Our ref: TR010022/S51 Response

1 July 2019

**A38 DERBY JUNCTIONS
PLANNING ACT 2008 SECTION 51: NOTIFYING PERSONS OF ACCEPTED
APPLICATION**

I am writing regarding the proposed A38 Derby Junctions scheme and your letters dated 21 May 2019 and 22 May 2019. Please see below the response of Highways England to the issues raised.

Drawing Number HE514503 -ACM	Originator -EGN-	Volume A38_SW_PR_ZZ -DR-LE-0112	Rev C01
---------------------------------	---------------------	------------------------------------	------------

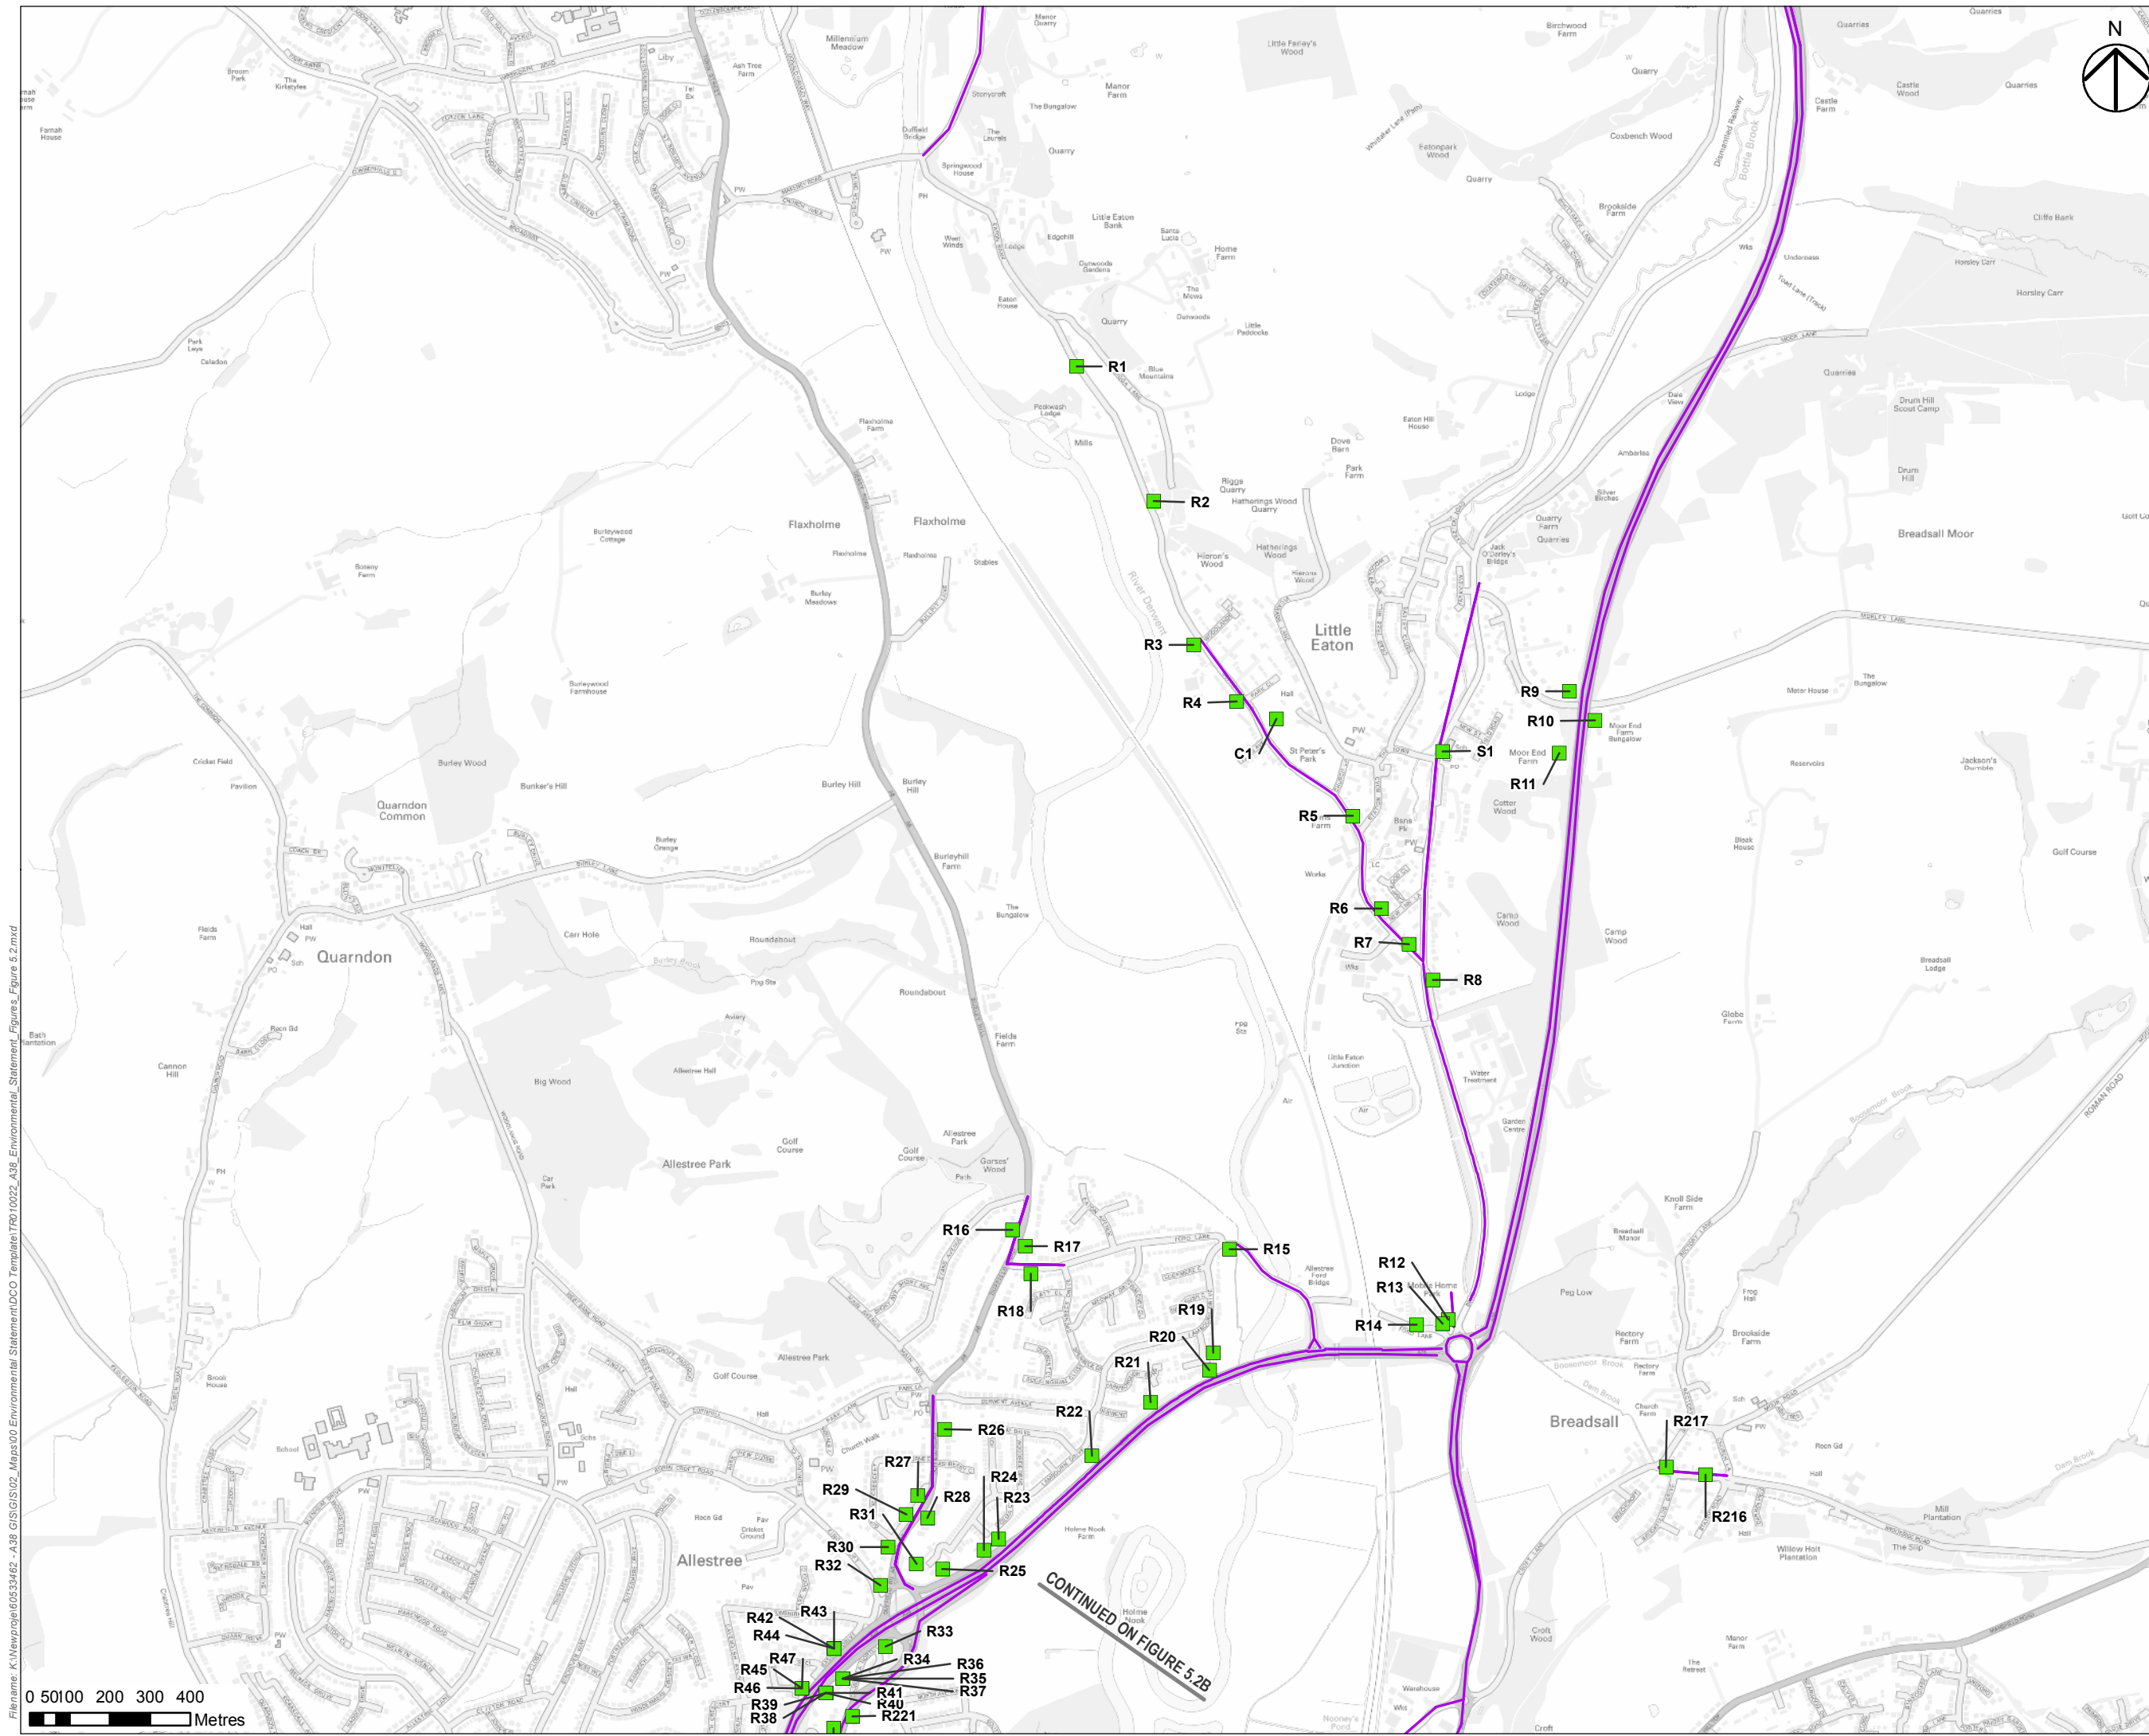
ES chapter 5, paragraph 5.6.2 states that the assessment of “operational phase traffic effects uses a study area of 200m around roads likely to be affected by the Scheme” and ES paragraph 5.6.3 sets out standard screening criteria used to determine study areas. Figures 5.2a-c and 5.3a-c set out the receptors considered in the construction phase and the opening year of operation. However, no detailed information is provided to explain how the selected receptors were derived with reference to the 200m study area and screening criteria thresholds. Please provide further detail regarding the findings of the receptor screening process set out in the ES.

The ARN for the Scheme opening year is presented in ES Figures 5.3 A-C. A similar exercise was undertaken to identify the ARN for the construction scenarios. The construction scenarios assessed are explained in ES para 5.5.6 - 5.5.7 and 5.8.8 – 5.8.9. The identification of the ARN is explained in ES Para 5.6.3 – 5.6.4. Additional figures have been produced (Figures 5 - 10, also enclosed with this response). These figures illustrate which road links are affected during the construction scenarios by changes in traffic flow or HDV flow, with the three construction scenarios assessed. The road links meeting the qualifying traffic screening criteria during any of the construction scenario were included in the ARN for construction impacts. The construction phase ARN is shown on ES Figures 5.2 A-C. The additional figures produced are:

Drawing Number HE514503	Originator -ACM	Volume -DCO	Rev C02
A38_SW_PR_ZZ	-DR-DC-9907		
Location	Type	Role	Number

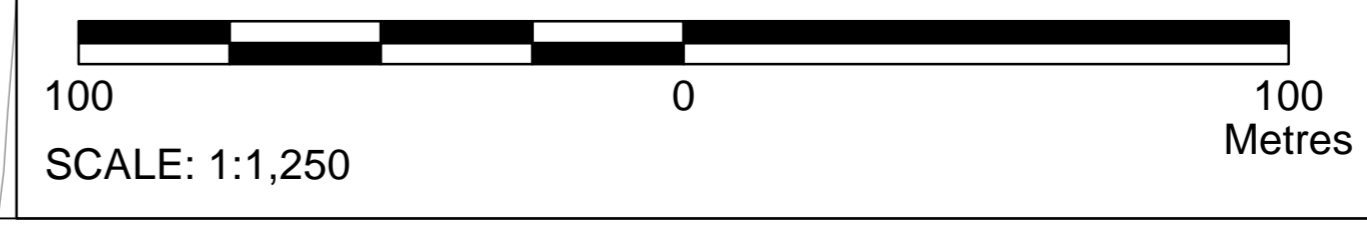
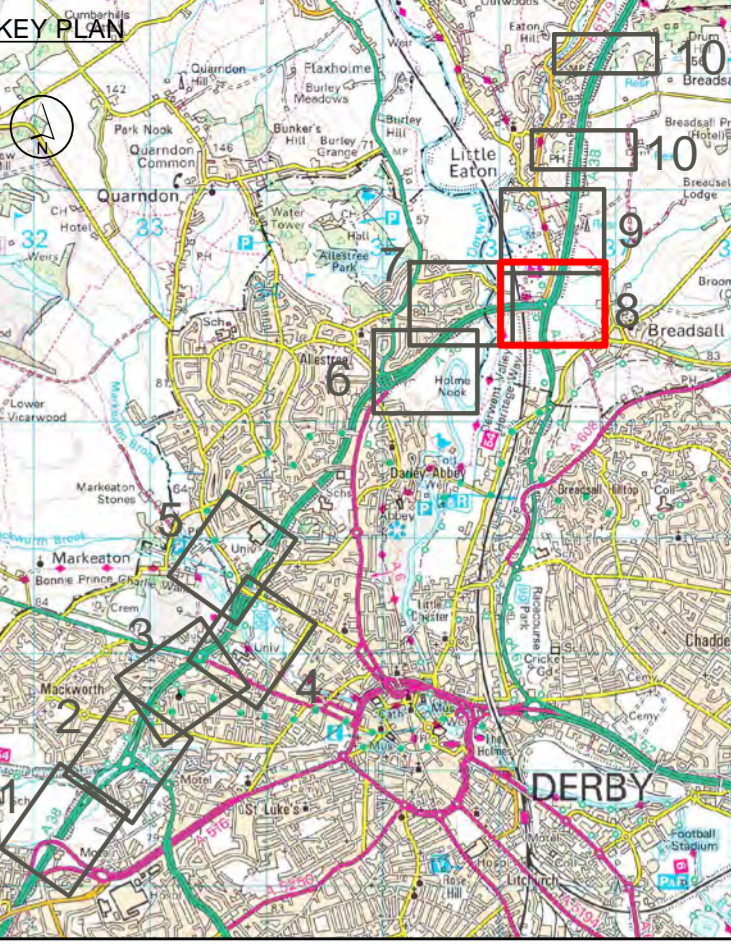
- Sheet 7 – Land outside DCO order limits highlighted yellow.
- Sheet 8 – 8/25c. Parcel is subject to cut-line. Amended and changed from green to blue. Reflected in BoR.

Accordingly, a revised set of Land Plans are provided (Sheets 1-11). These plans update the submission version and should be used in the examination of the application.
